In the matter of ABP-320094-24

Proposed 400kV Gas insulated SwitchGear electricity substation and high voltage transmission lines/cables and electric plant, Coolpowra, Co. Galway

Observation	ABP-320094-24 — Proposed 400kV Gas insulated SwitchGear electricity substation and high voltage transmission lines/cables and electric plant.
One project	Co-located and, on the applicant's own concession, functionally connected: this GIS; the Reserve Gas-Fired Generator (ABP-320095-24); and the Long Duration Energy Storage Facility (ABP-320916-24).
Applicant	Coolpowra Flex Gen Limited (and related entities).
Submitted by	Eamonn O'Hara, Neale, Killimor, Ballinasloe, Co. Galway
Date	June 2026

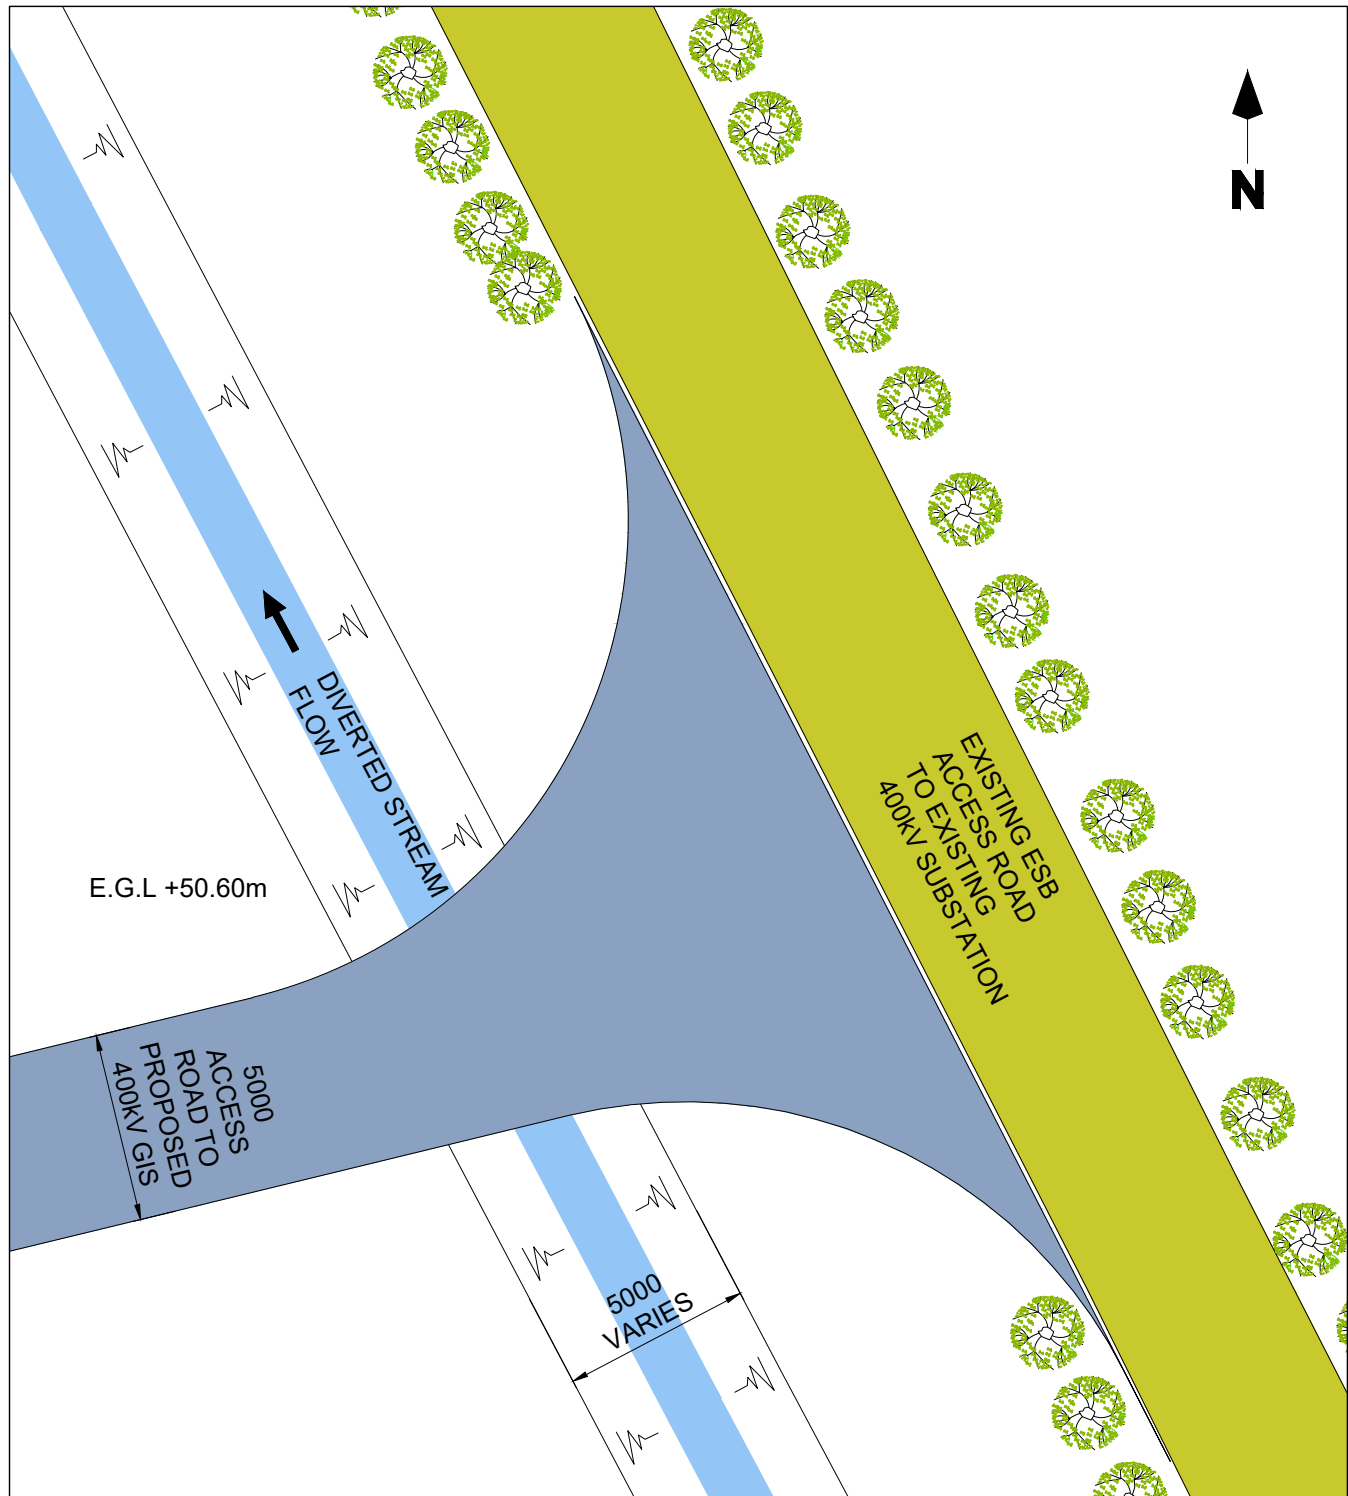
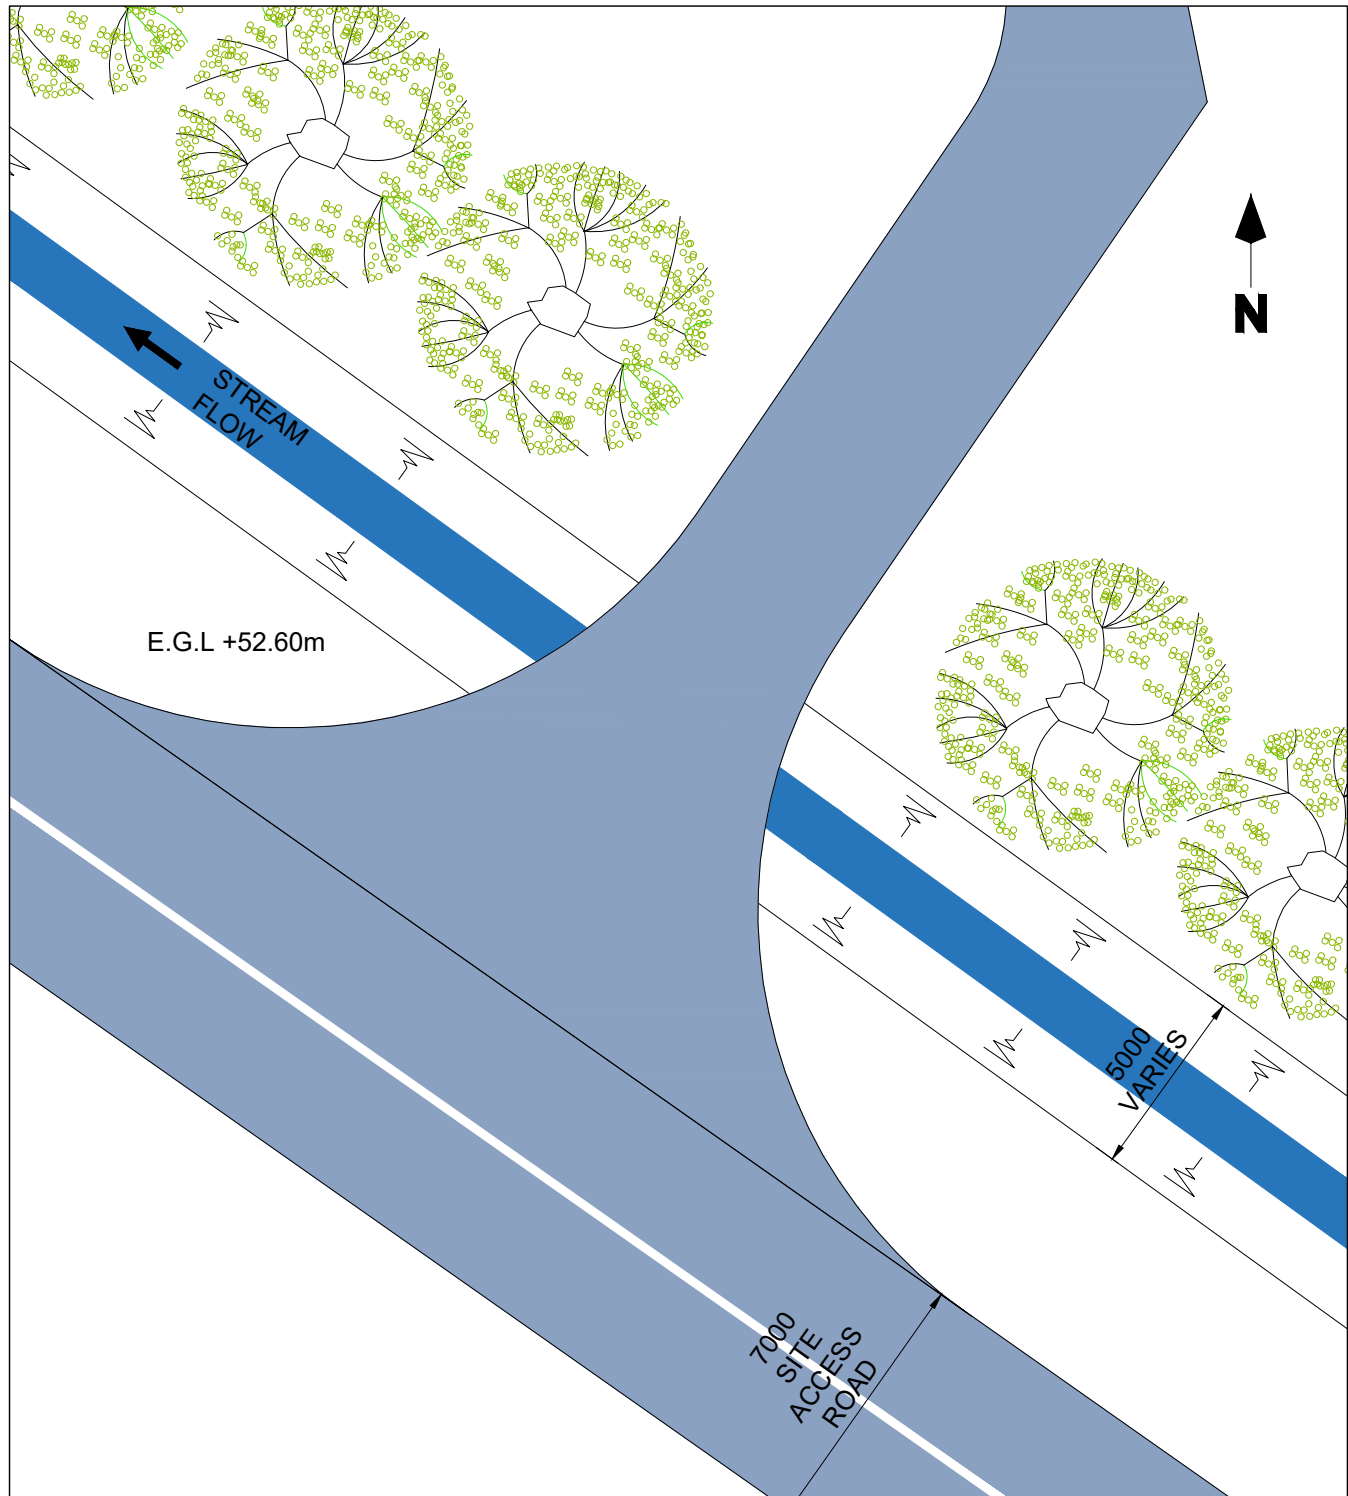
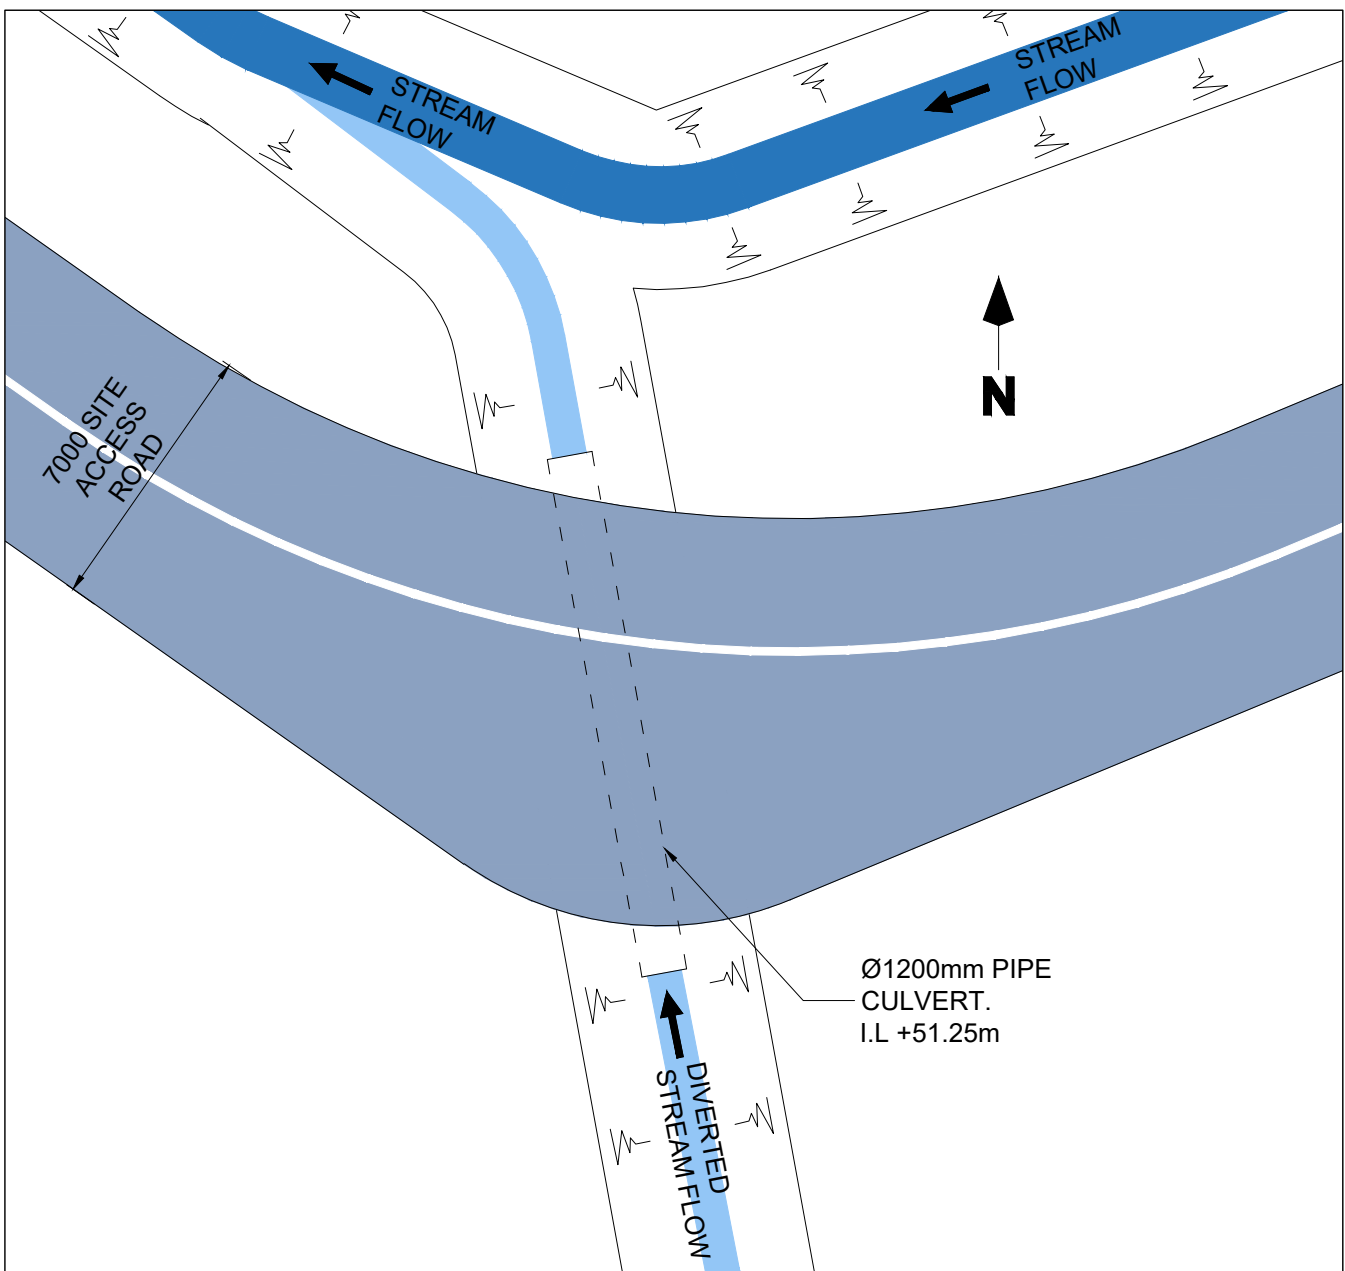
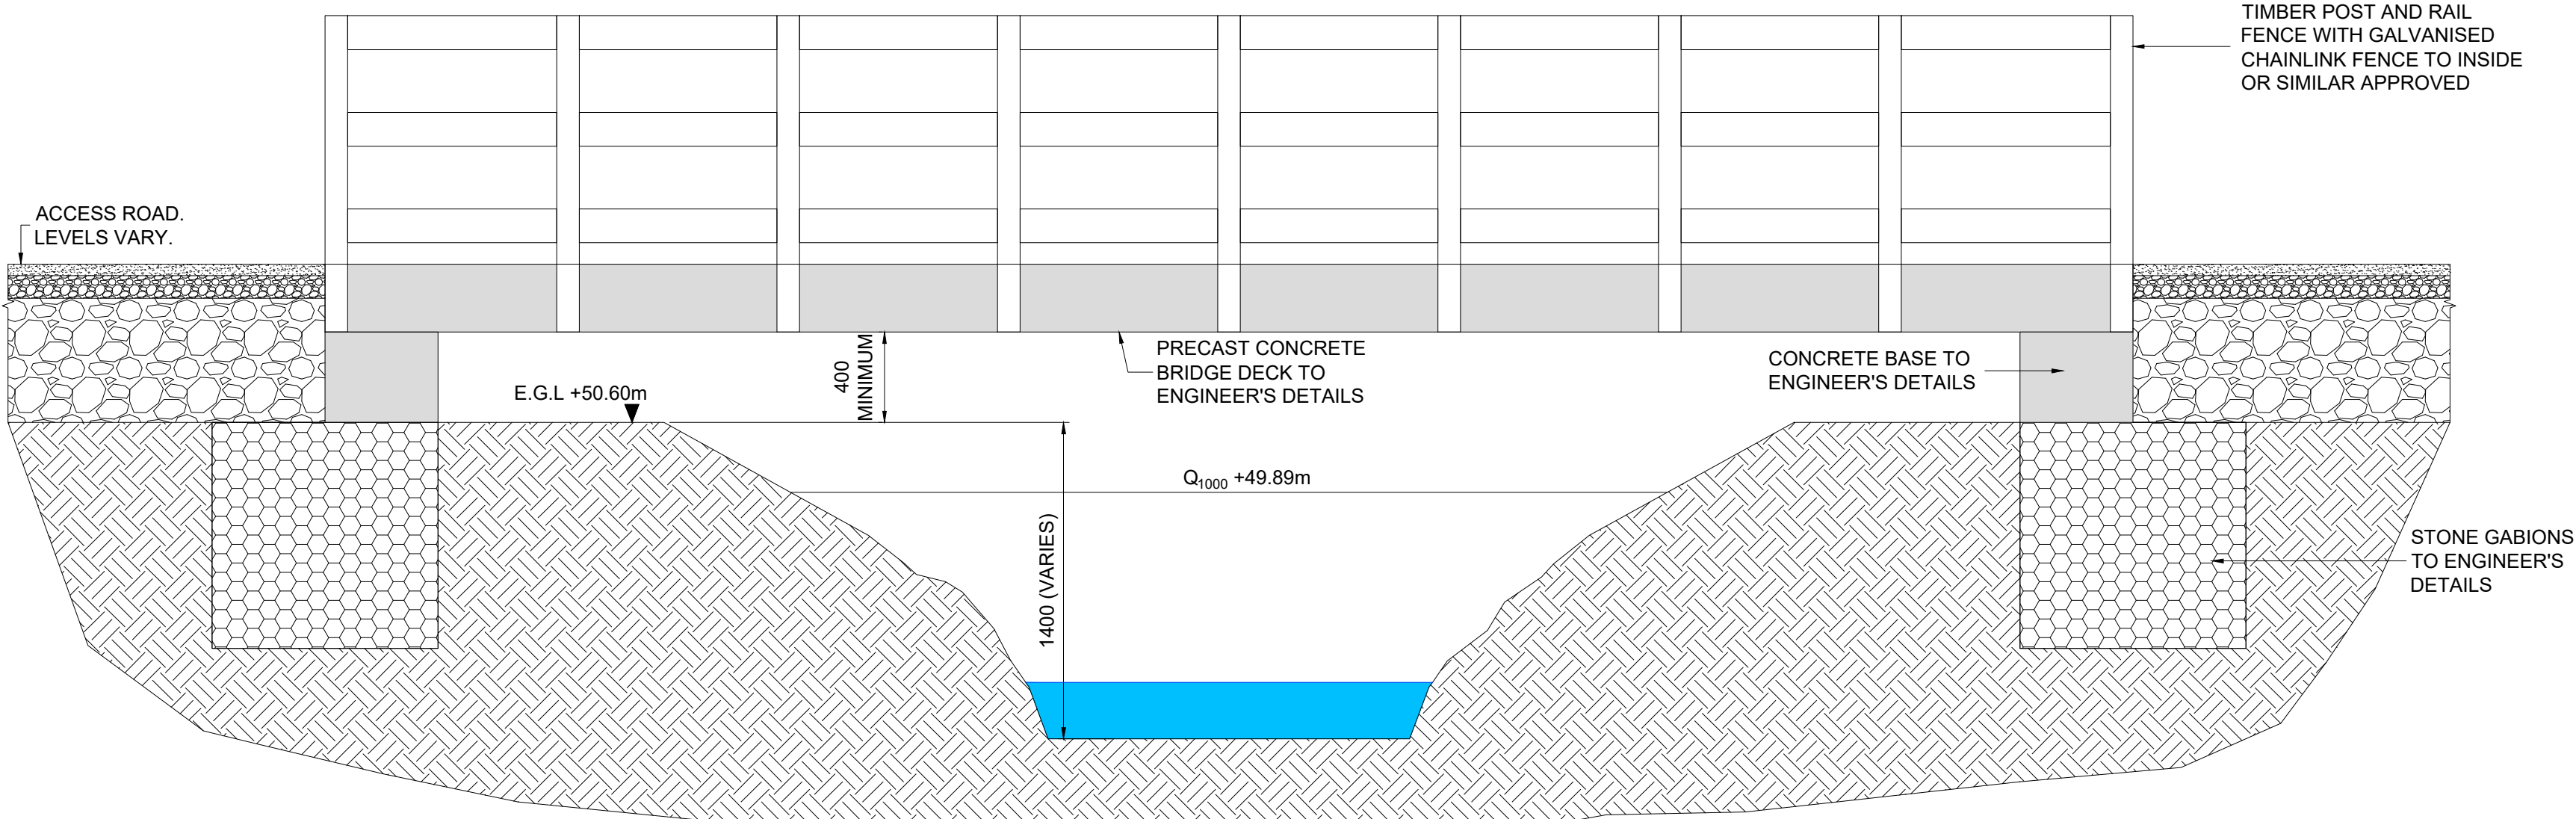
The deficiencies are these. No evidence of consultation with Inland Fisheries Ireland appears in the response, despite the express requirement. The "no fisheries value" claim is internally contradicted: the same material designs the realigned channel for "fish passage and spawning," and the downstream Kilcrow holds salmon, trout and eel. The claim rests on a walkover with no named fisheries author and no electrofishing data. It is also contradicted by the State's own science: the Treananearla is a tributary of the Kilcrow, which the genetic stock study (Magee et al., 2017) found to be among the lake's top contributing tributaries — about 11% of Lough Derg's adult brown trout, behind only the Camcor (13%). Absence of sampling is absence of investigation, not absence of value. The realignment is, moreover, justified expressly to "consolidate" the plant layout near the Oldstreet node — that is layout convenience, the opposite of the requirement to avoid impacts before mitigating them.
